Cleve Hill Solar Park

DCO Application Reference EN010085

Answers to the Examination Authority's Further Written Questions and requests for information (ExQ2) from

Kent Wildlife Trust

Figure 5: Arable Reversion Habitat Management Area [REP7-011: Figure 2].

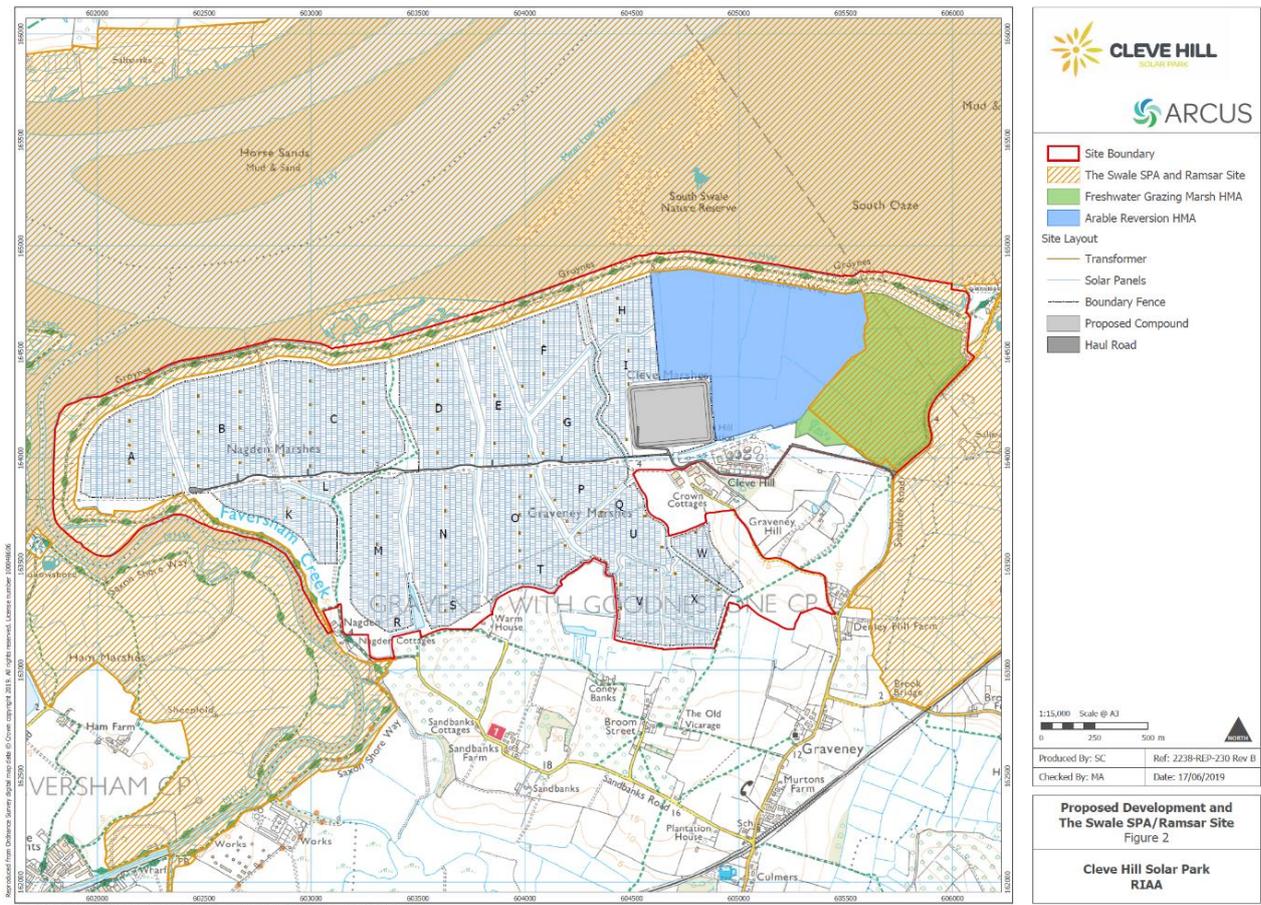
As currently written REP3-005 requires some revision with regard to the AR HMA. The seed mix for the AR HMA was discussed at the Habitat Management Steering Group (HMSG) and we understand the LBMP will be revised accordingly to reflect this. We also understand that errors that crept in during revisions (such as that picked up in ExQ2.1.13, and the references to Appendix A in Paragraph 15) will be corrected.

At present, the implementation of the AR HMA comes after the start of construction (rather than construction starting after the mitigation has been confirmed to have established), but before the first winter when the impacts on Brent geese, lapwing and golden plover can be expected. It would be much more preferable to implement the AR HMA and establish the mitigation prior to the start of construction (and therefore impacts). We have requested monitoring between implementation and the first winter that isn't currently included in REP3-005, so that any issues can be picked up sooner. It is possible that establishment of the AR HMA (or GMG) does not go according to expectations, leading to a reduction in carrying capacity for the target species. In such a case, it would be advisable to halt construction with respect to avoiding further loss of carrying capacity until habitats have established.

In addition to our answer to ExQ2.1.5, with regard to monitoring, we note the applicant's preference for use of ivermectin-free manure in the AR HMA to 'avoid adverse effect on invertebrates' (invertebrate being the food source of lapwing and golden plover) but that this will be used 'where possible'. We have highlighted to them that this creates a potential conflict between management for Brent geese and management for lapwing and golden plover. We have requested that this be taken into account in the monitoring, such as through mapping of areas where treated and ivermectin-free manure is used, and monitoring invertebrate biomass.
